Recommendation Report for Works to Tree(s) on trees subject to a Tree Preservation Order (TPO)

REF NO: AW/5/20/T

LOCATION: 1 Seabrook Close  
Aldwick  
PO21 3UT

PROPOSAL: Crown reduction to 4 No. Oak trees to 16m (T1, T2), 15m (T3) 15m (T4).

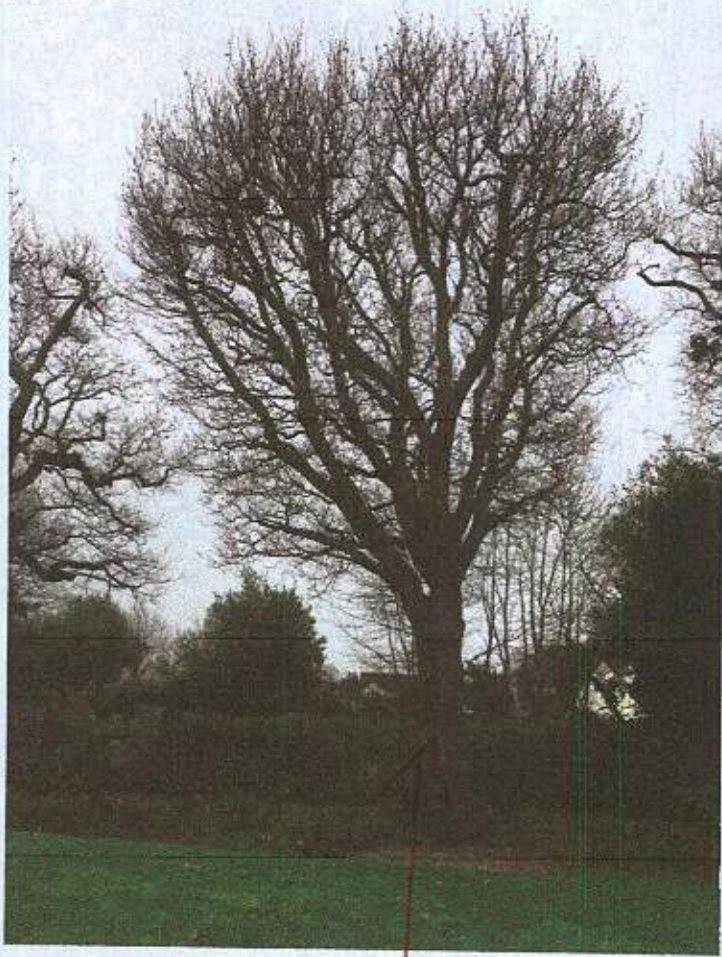
T1 pedunculate oak / Quercus robur Height: 15-20m Spread: 0-5m Age class: Early mature

- Outwardly appears to be in a fine physiological state. Presents a slightly 'drawn-up' form having lost a co-dominant stem from near ground level. Previously the subject of crown reduction work, 1-2m new growth from pruning cuts.

T2 pedunculate oak / Quercus robur Height: 15-20m Spread: 5-10m Age class: Mature

- Outwardly appears to be in a fine physiological state. Previously the subject of crown reduction work, 1-2m new growth from pruning cuts. Nonetheless presents an attractive full crown-profile.

T3 & T4 pedunculate oak / Quercus robur Height: 10-15m Spread: 0-5m Age class: Early mature

- Outwardly they appear to be in a fine physiological state, although have erratic form due to mild suppression from neighbouring trees and past pruning work. 1-2m new growth from most recent pruning cuts. Nonetheless valuable constituents of the group.

· T1 - The proposal to fell this tree has not been justified on arboricultural grounds. It has significant growth potential and is an important constituent of the tree group.

· T2, T3 & T4 - The proposal to reduce their overall height and spread with a view to restricting growth is consistent with previous works approved by the Local Planning Authority. If the work is undertaken to a high standard and at the right time, then the trees should be able to remain as long-term visually interesting features in the local landscape.

The Applicant has amended the application to fall in line with the comments of the tree officer. As such the works to T1 are now crown reduction as per the specification of T2.
